WEST SUSSEX COUNTY COUNCIL CONSULTATION

TO:	Arun District Council FAO: James Cross
FROM:	WSCC - Highways Authority
DATE:	1 June 2020
LOCATION:	Land Rear Of Poachers Eastergate Lane Eastergate PO20 3SJ
SUBJECT:	BN/46/20/PL Construction of 1 No. 4-bed detached dwelling with detached carport. This application is a Departure from the Development Plan.
DATE OF SITE VISIT:	n/a
RECOMMENDATION:	Modification
S106 CONTRIBUTION TOTAL:	n/a

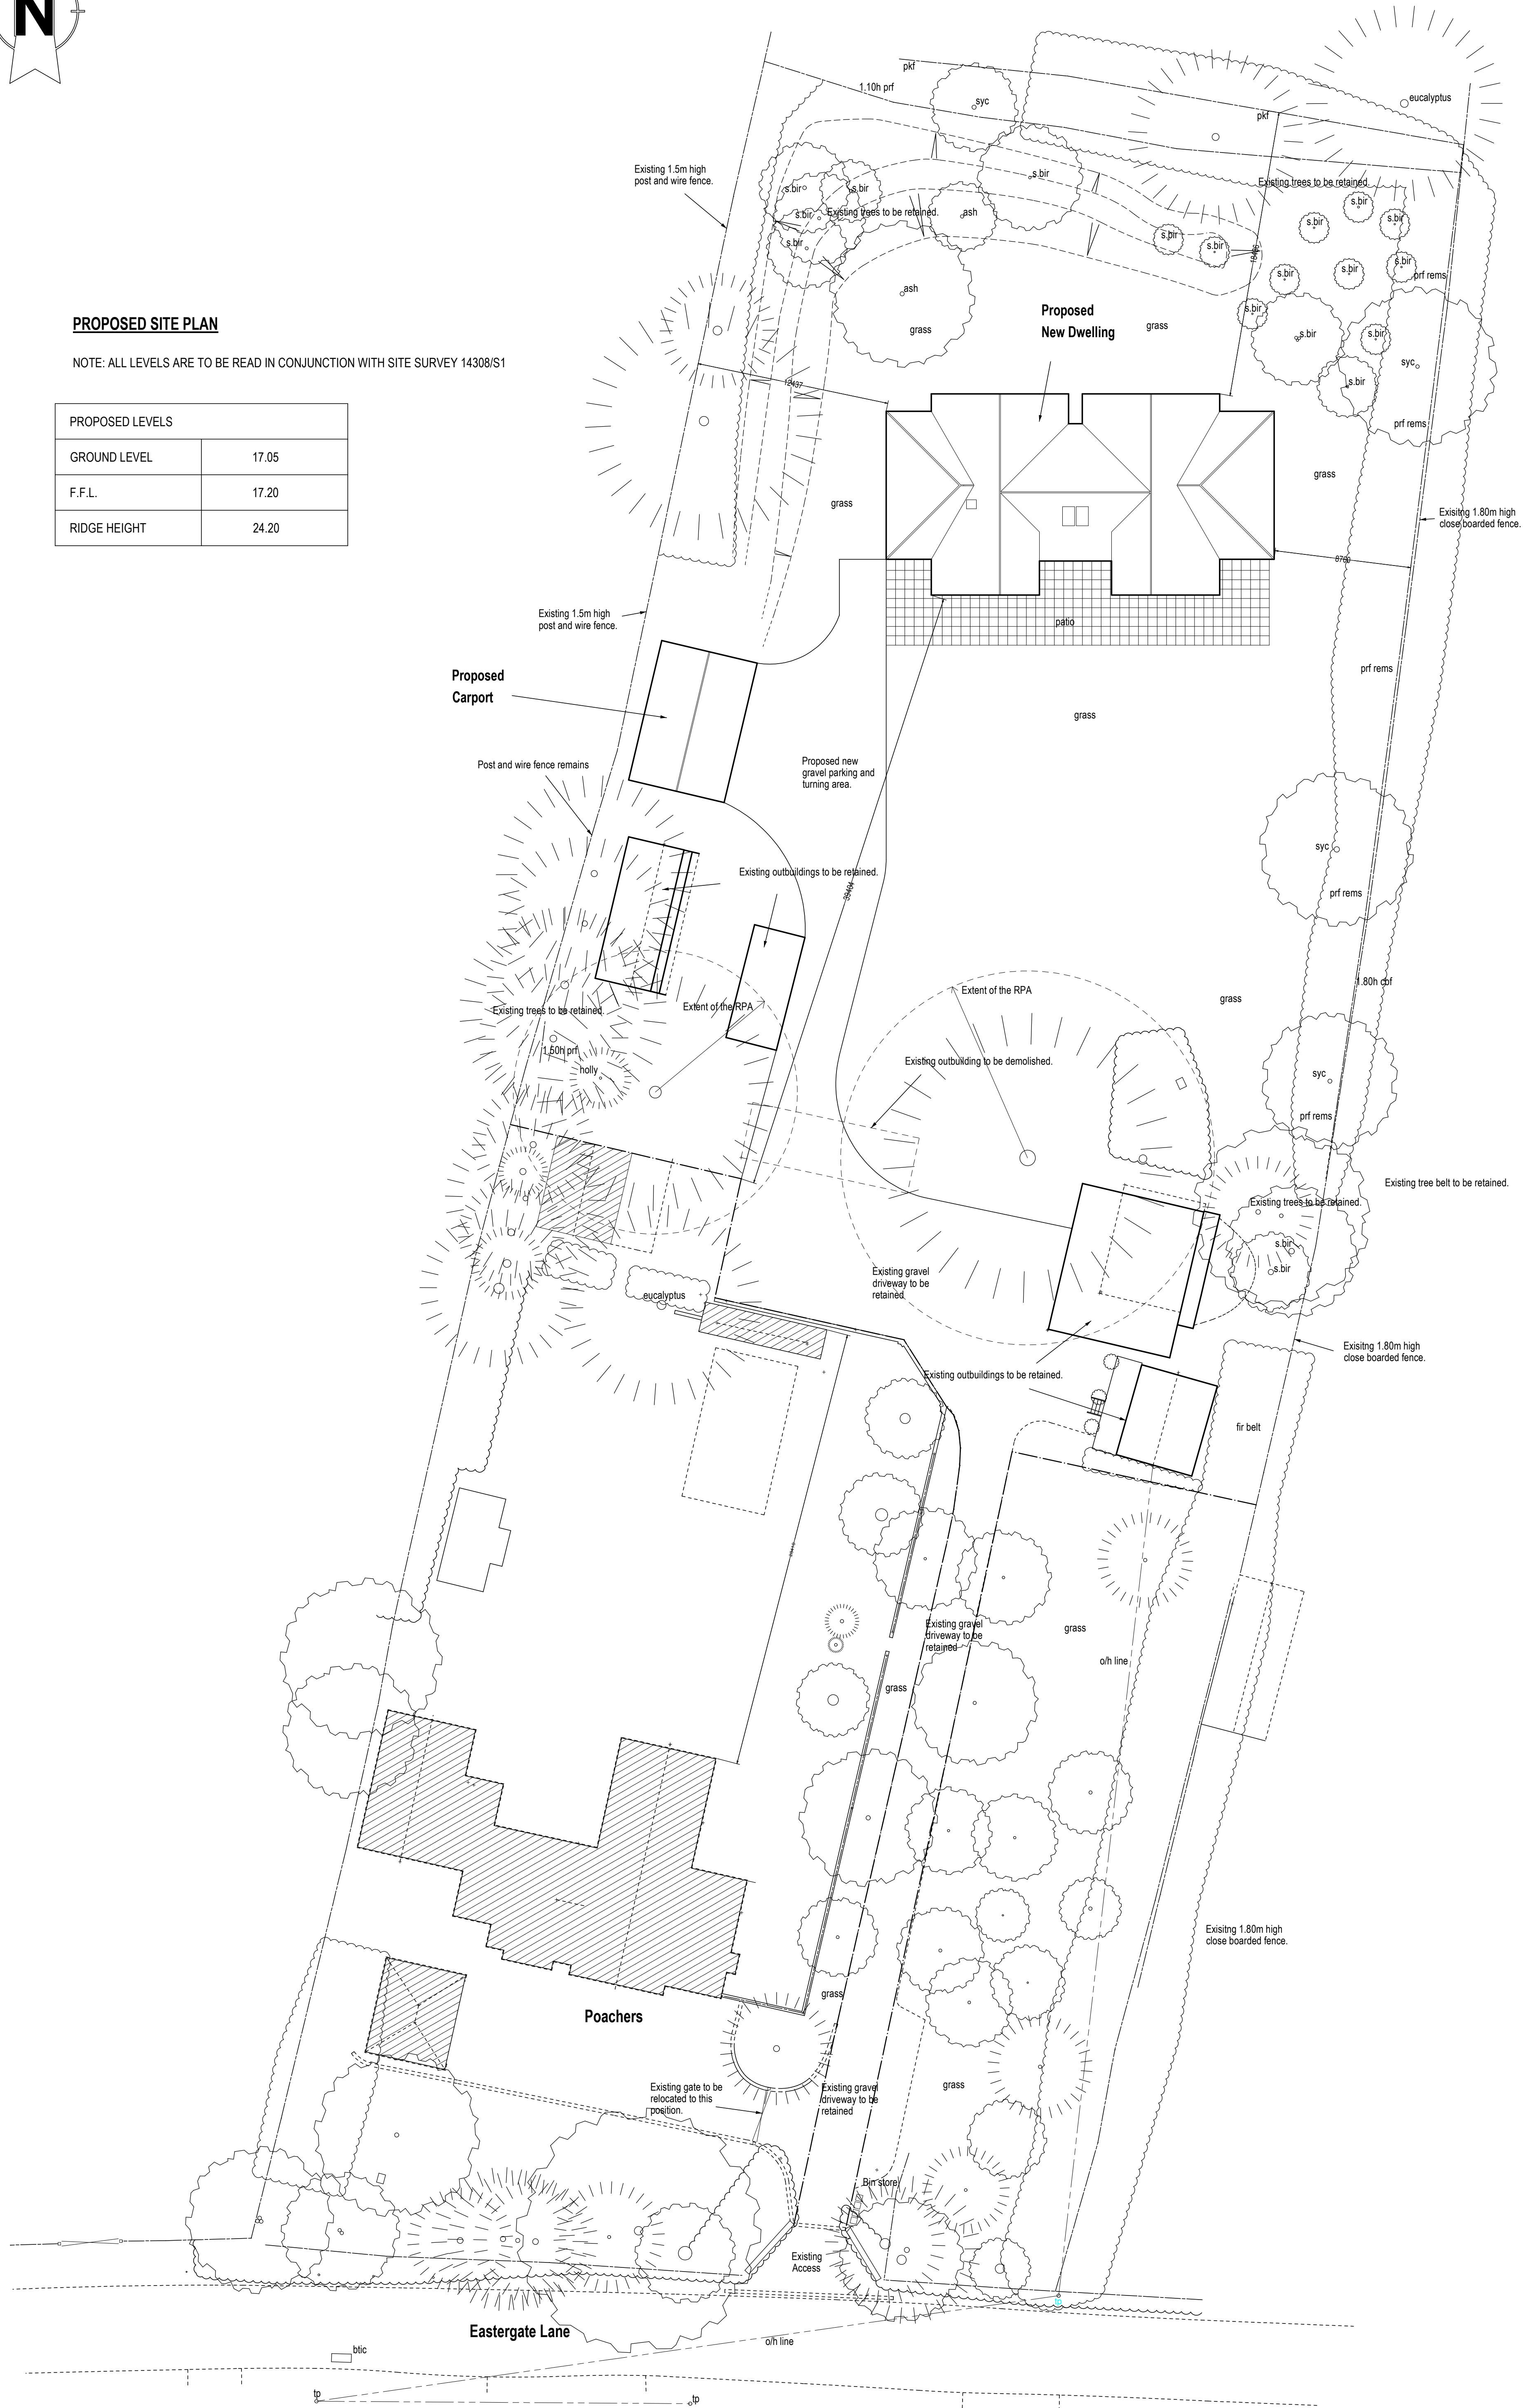
The applicant has proposed a nil cycle parking provision, as per the WSCC Sustainability policy we wish to see cycle storage implemented in the form of lockable covered storage demonstrated on the plans.

There is no sign of any waste storage or collection points on the proposed site plan.
